October 8, 2018
Revised: March 30, 2021
Revised: August 5, 2021

Subject: Geologic Hazard Evaluation and Preliminary Geotechnical Investigation
Haven Valley (formerly Patriot Village)
Alturas Drive and Cable Lane
Security-Widefield, Colorado
CTL|T Project No. CS18980-115

Sheet 1 - Description, Dedication, Notes and Certificates Sheet 2 - Plat Graphic, Lots & Tracts

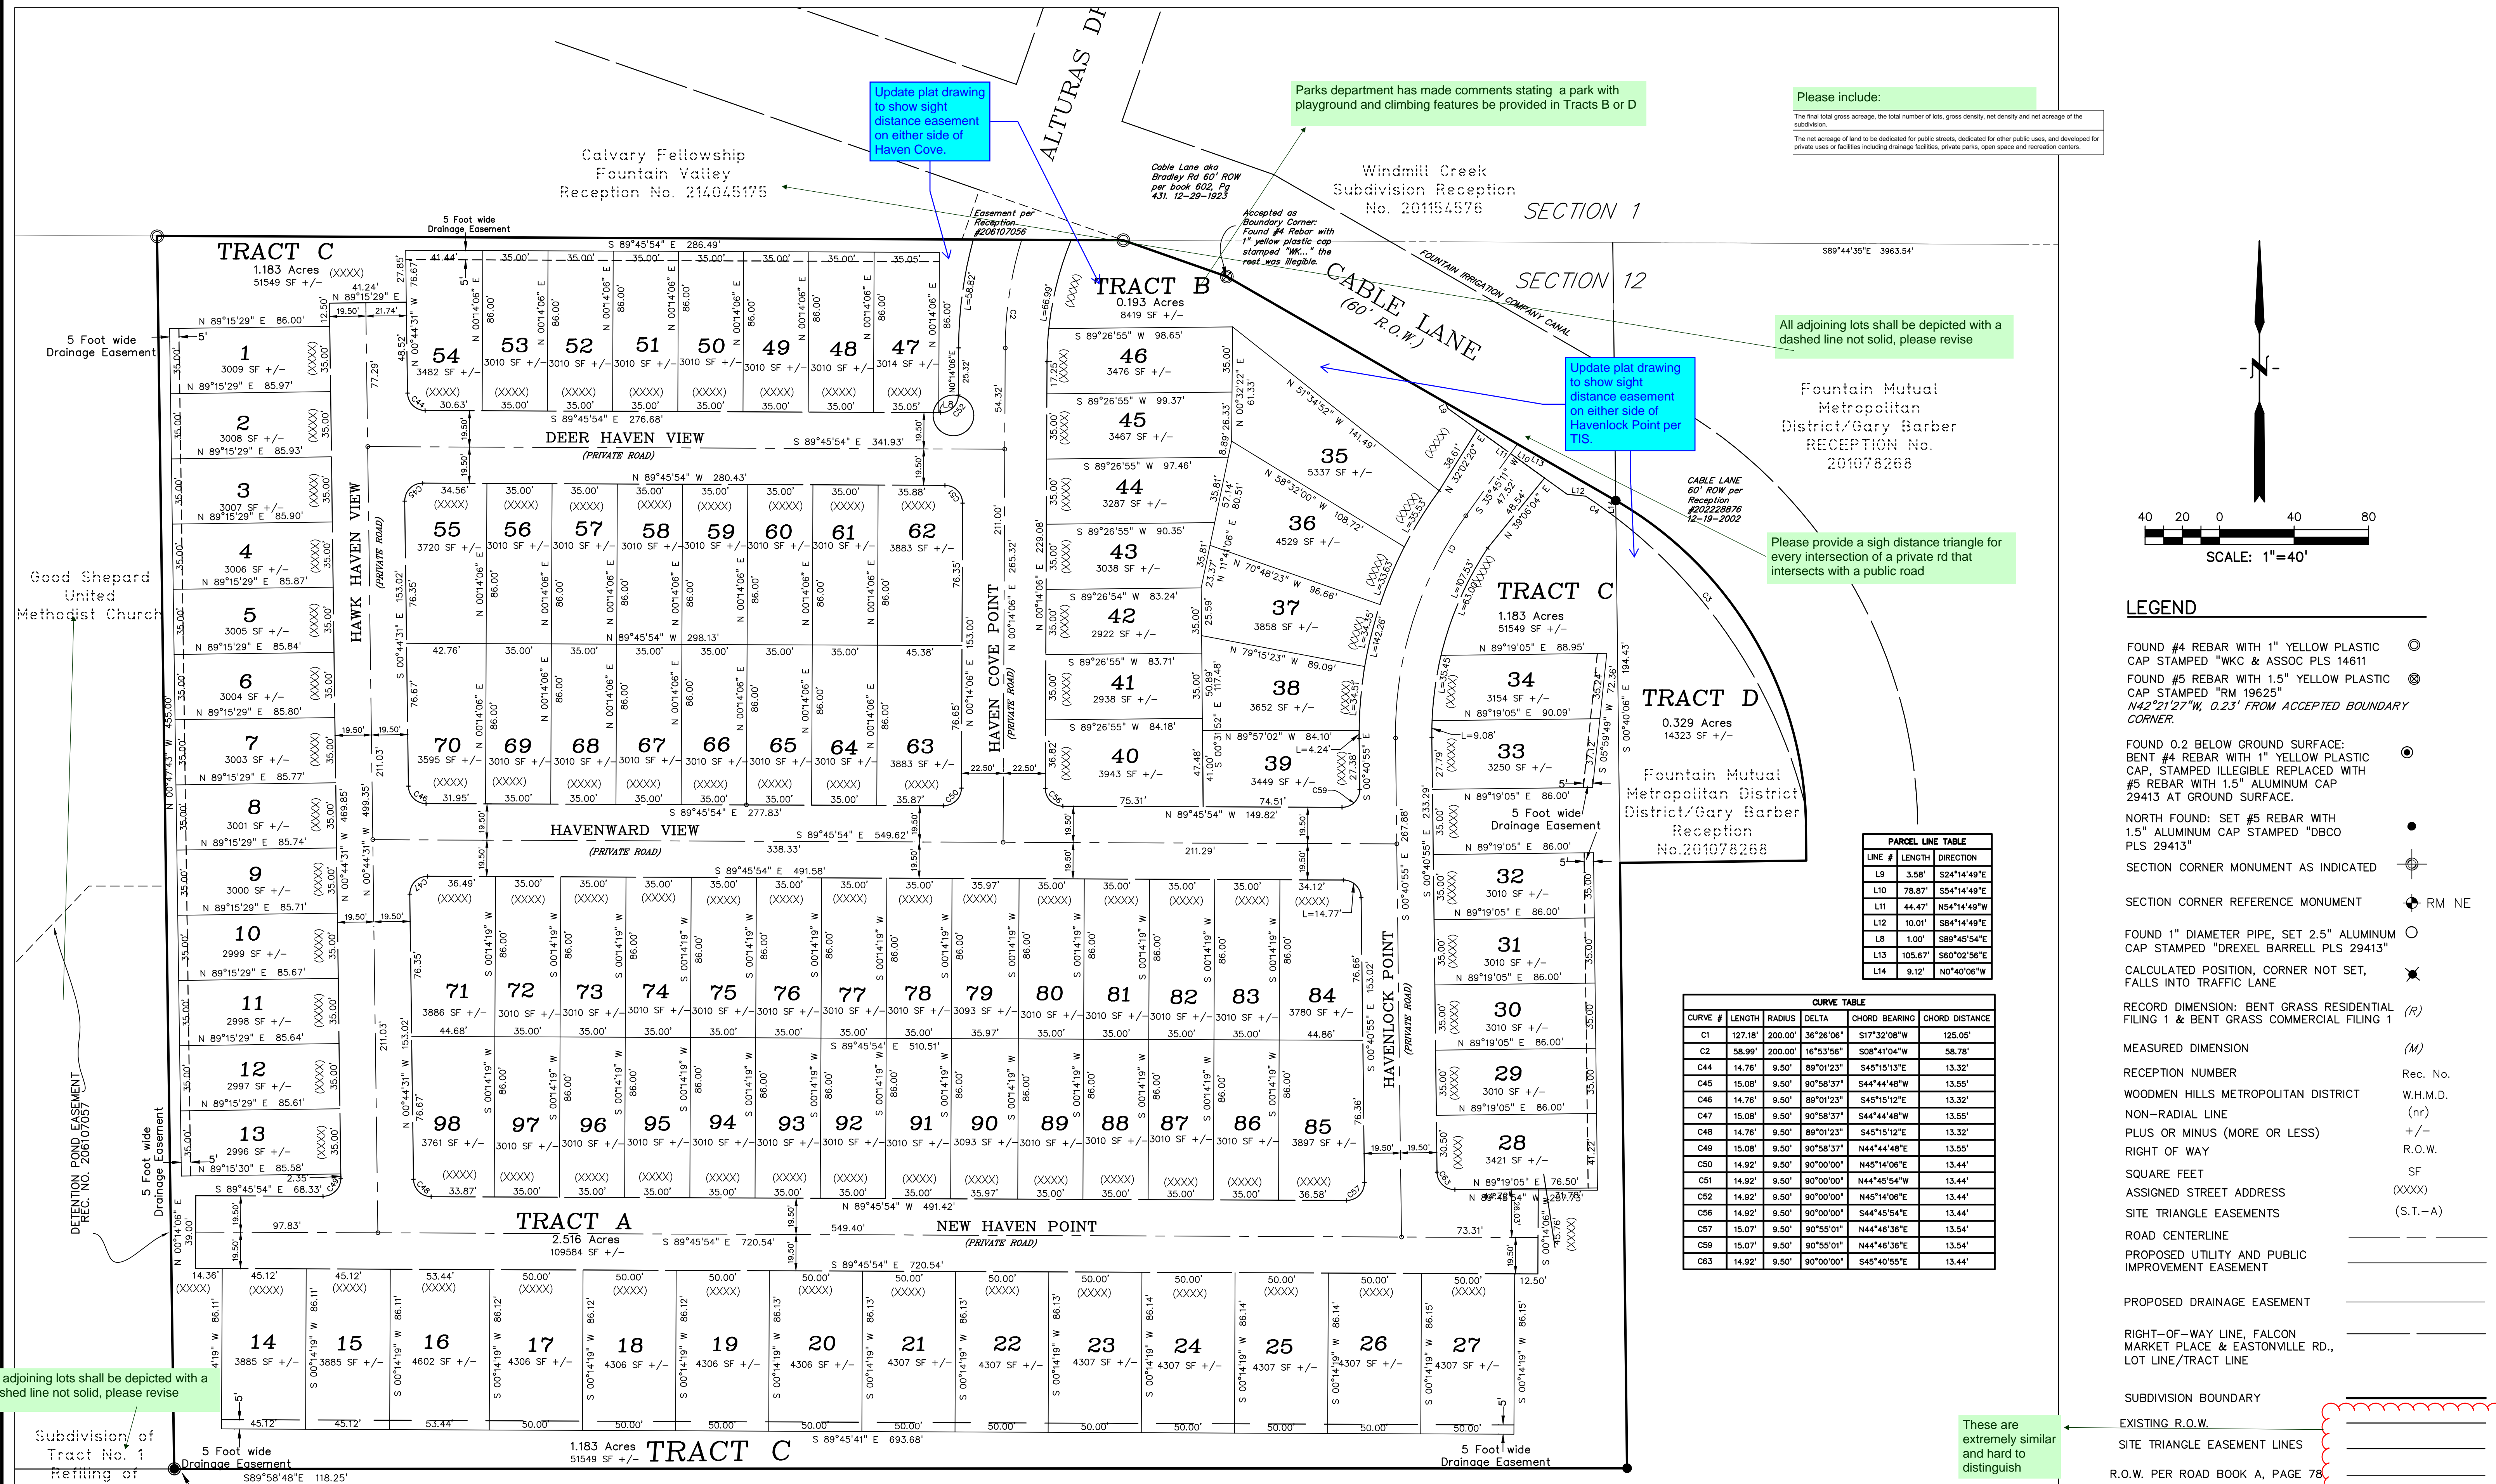
The geo hazard note on the plat should reference this, "see page 5-9 for more information about undocumented fill and special precautions to take"

this should be added within the geo hazard note as well
